STOP GREEN HILL SOLAR

RESPONSES FURTHER TO REP3-074; GH8.1.19 (APPLICANTS RESPONSES TO ExA SECOND WRITTEN QUESTIONS)

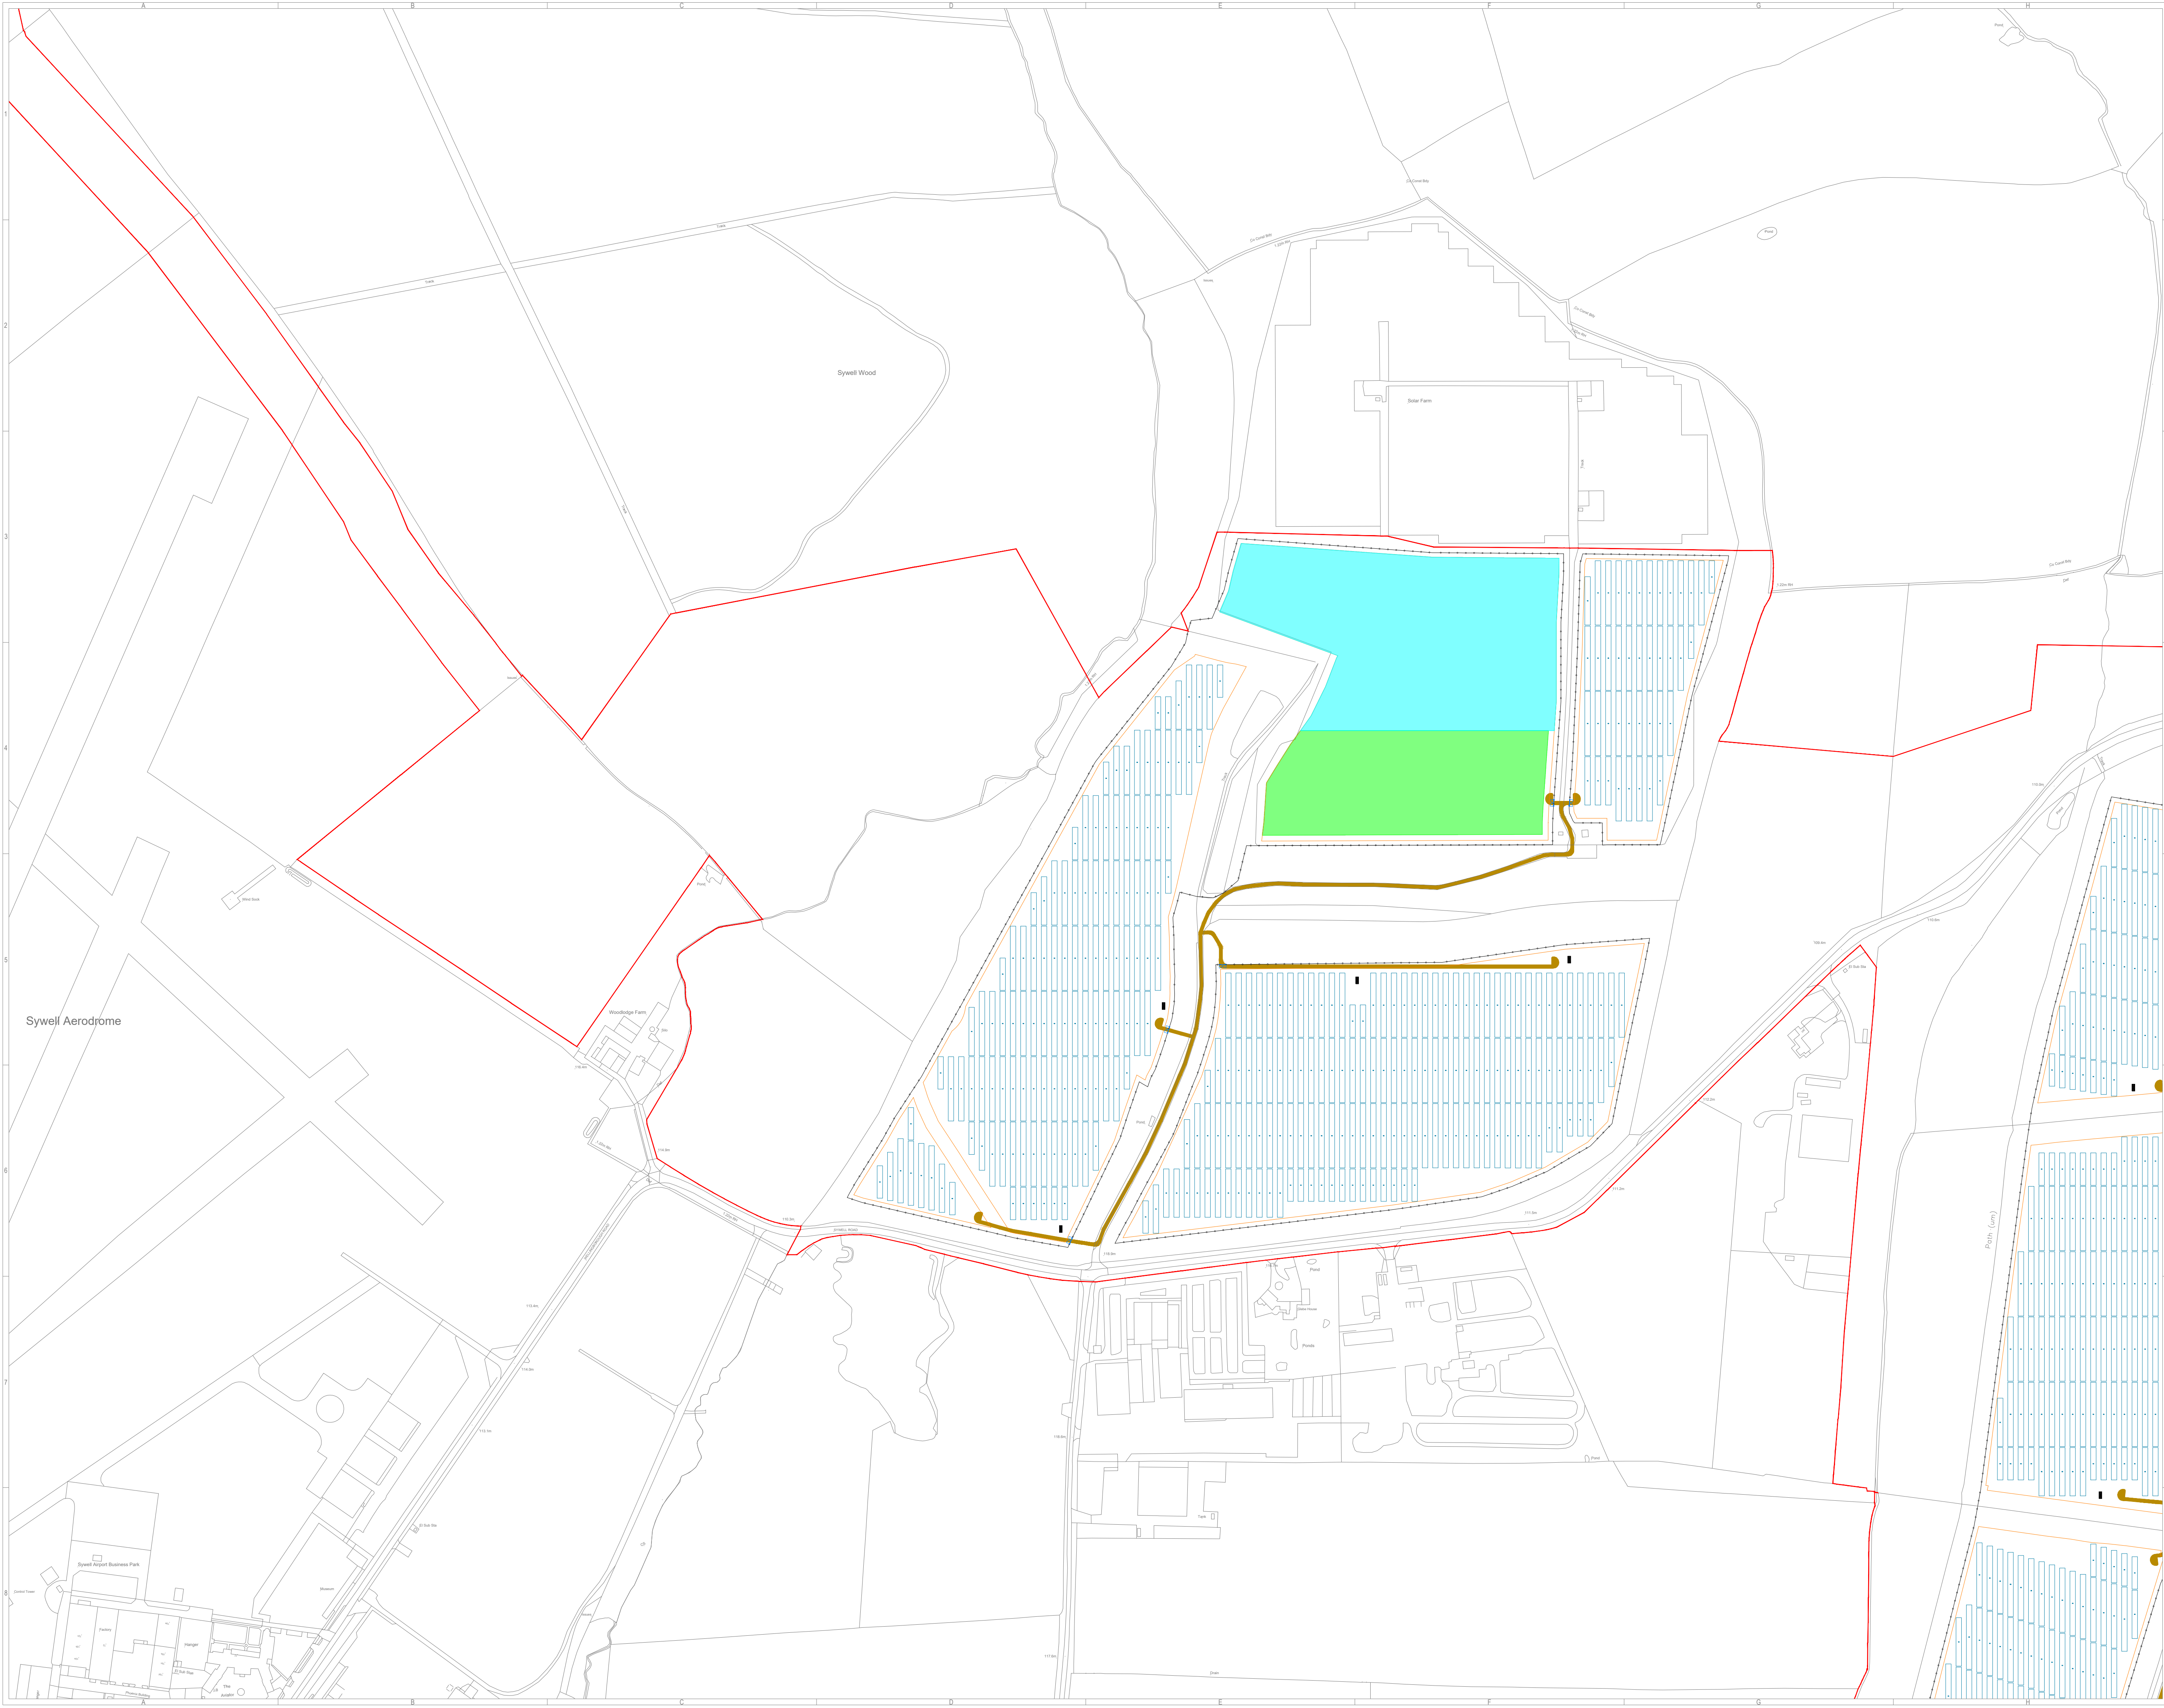
Q2.16.10	SGHS	Public access to the countryside and perceptions of safety: Stop Green Hill Solar's Landscape and Related Matters Statement [REP1-195] raises concerns regarding public safety when using fenced		At present, as one walks along the Green Lane, there are two main options for escape. Firstly, there are wide entrances to each field on either side – some have gates, mostly they are not secured and can be opened, all would be relatively easy to climb over, and some there is space to walk around the posts on one or both sides. Secondly, there are some gaps in the hedgerows, more obvious in winter, where it would be possible to get through. Once in any of the fields to the east, these are all open arable, and many connect easily through to the Kettering Road. On the west side, there is only one field's width to Newland Road, and all fields have field gates on the Newland Road as well. If the proposed development received consent, as far as can be determined from the Illustrative Layout Plan for Green Hill A, GH 6.4.4.1, APP – 193, these opportunities for escape would be affected in several ways.

Title:
Figure 13.5: Routes to Scheme Sites (South Area)

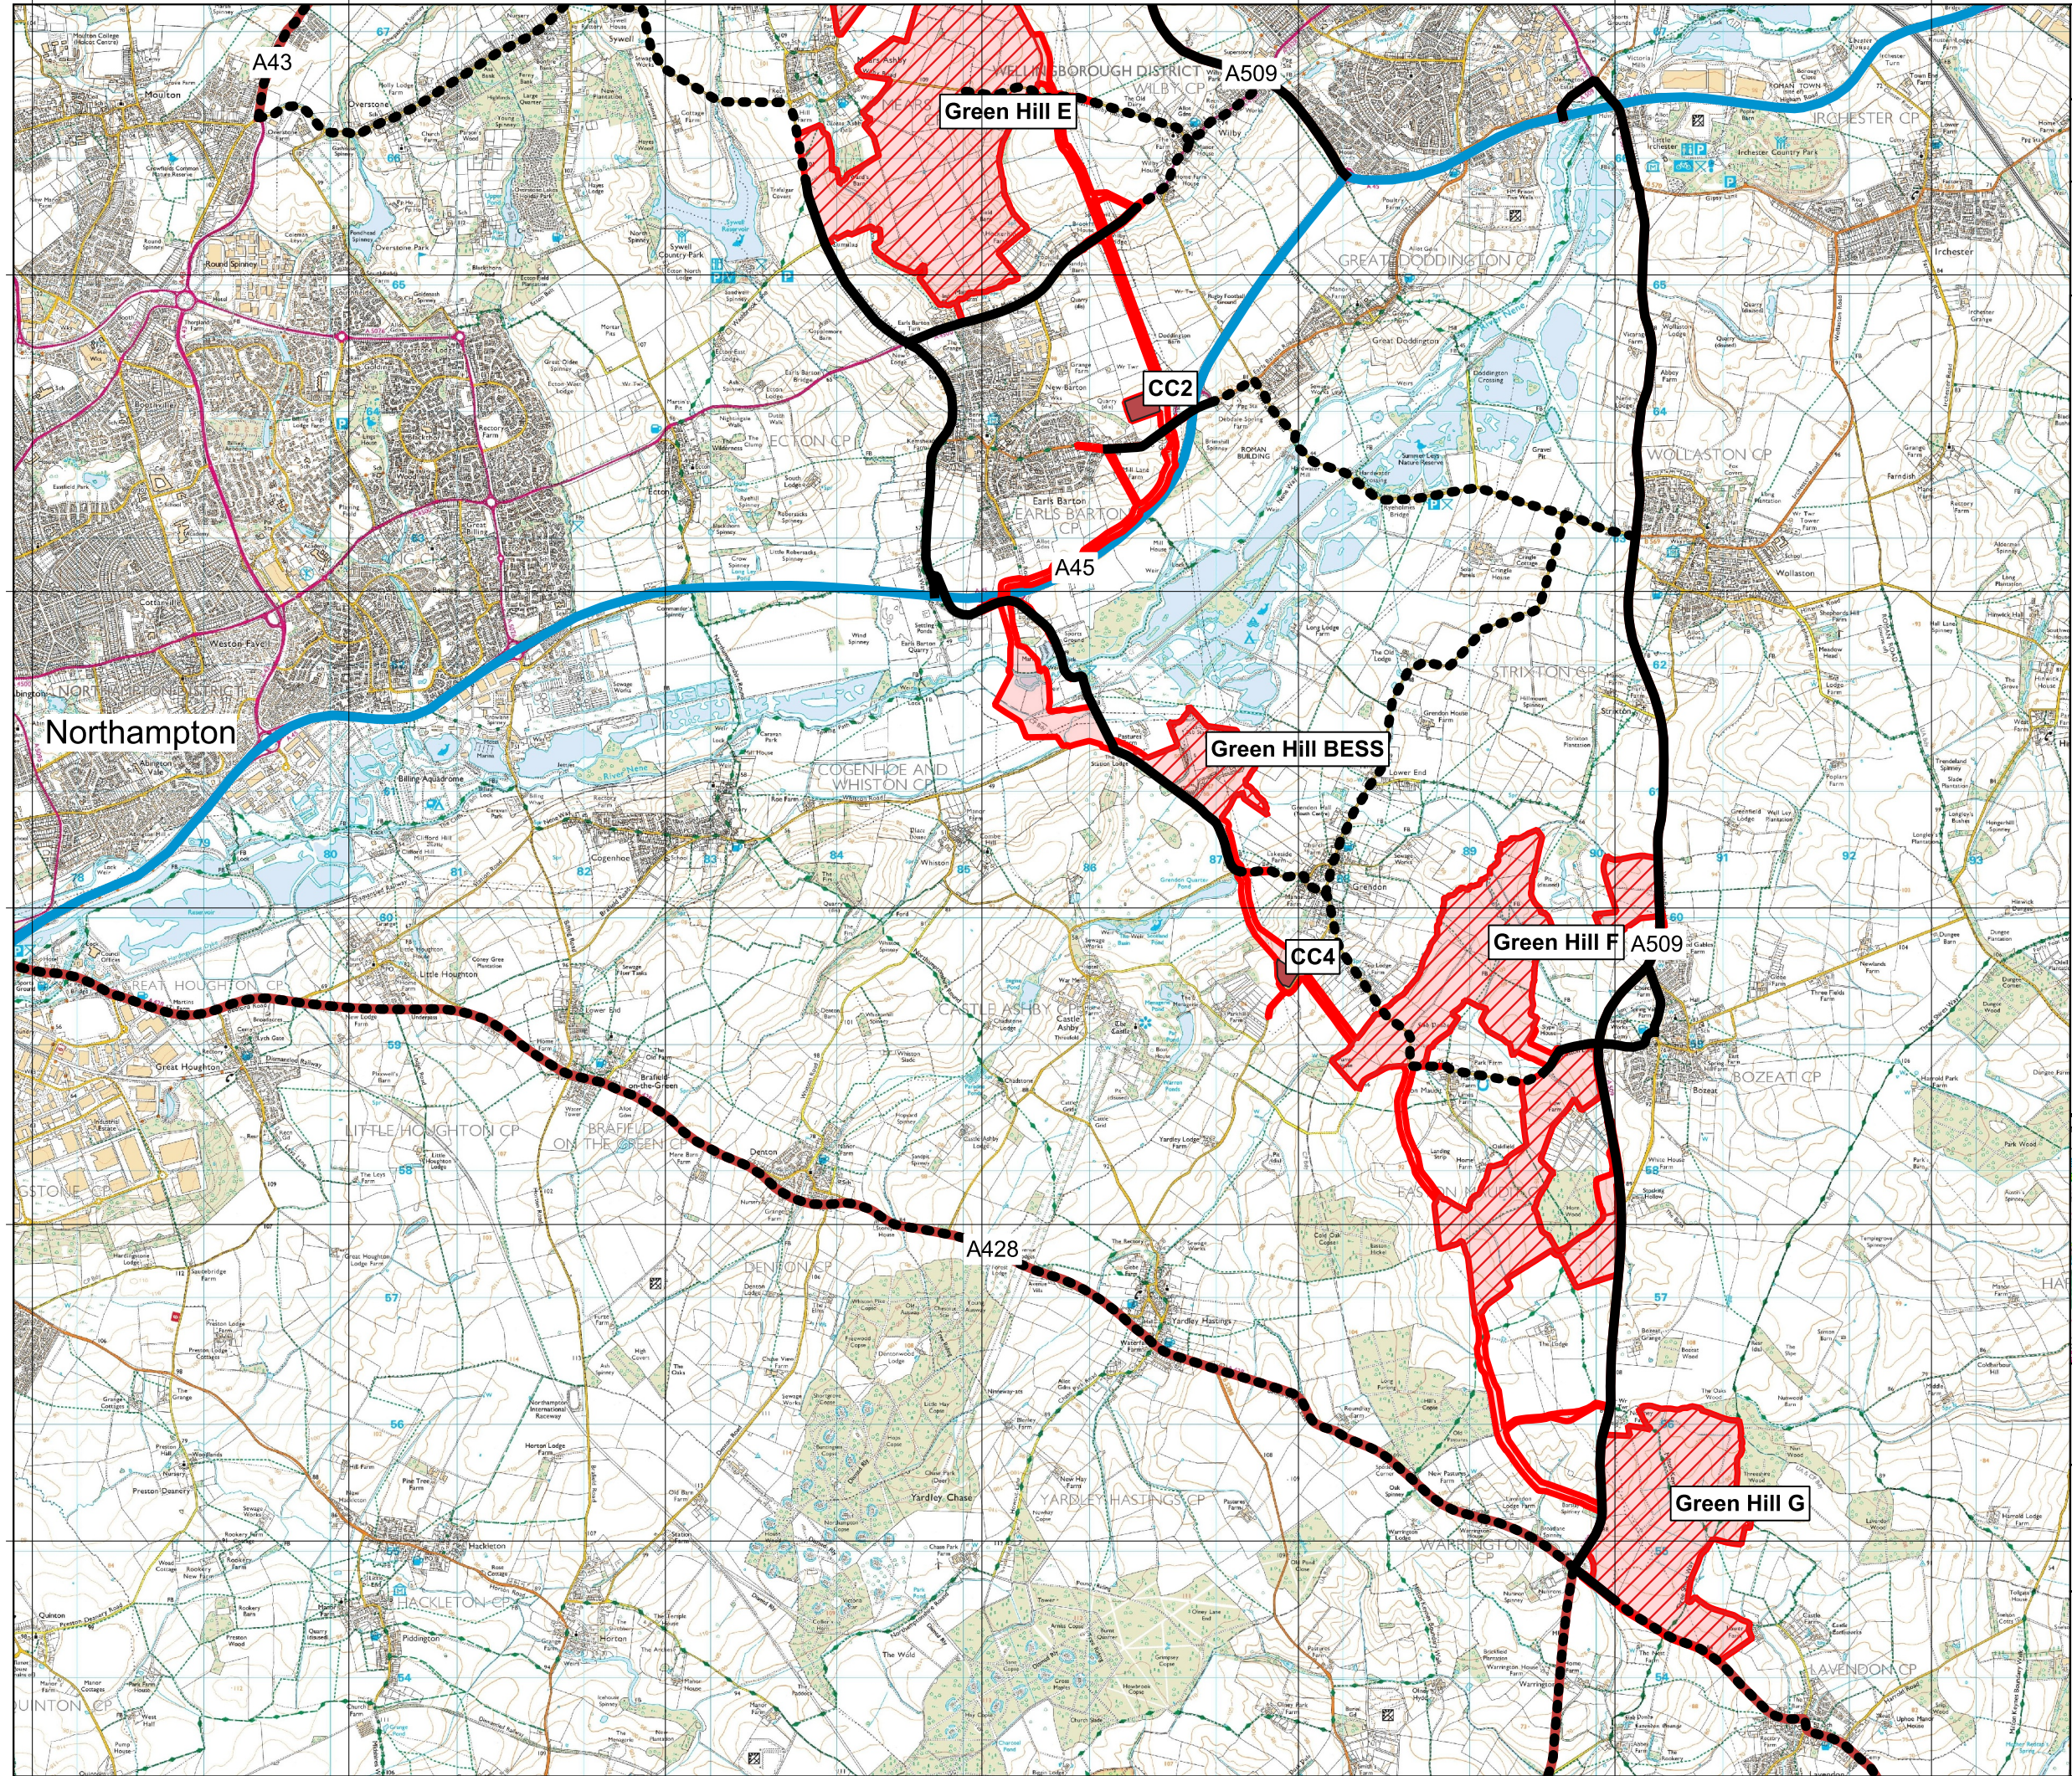
ExQ	Respondent	Question	Applicant's Response	SGHS Comments
Q2.16.4	The Applicant	Access to Construction Compound 4	...It is proposed for construction traffic movements to route via Station Road to access CR18, and then route south along the internal haul route south from Station Road to access the compound.	SGHS wishes to comment: Has the applicant calculated the amount of HGV traffic that there will be to construct the internal haul route? Experience with the construction of the Statera BESS demonstrates that the amount of traffic generated just to construct an internal haul route is considerable. Also, given that the internal haul route will inevitably be constructed from MOT or similar, what plans are in place for the removal of the internal haul route once the construction has finished? This road will cause a very obvious visual scar on the landscape just outside the village and adjacent to the Grade 1 listed park and gardens of Castle Ashby Estate.
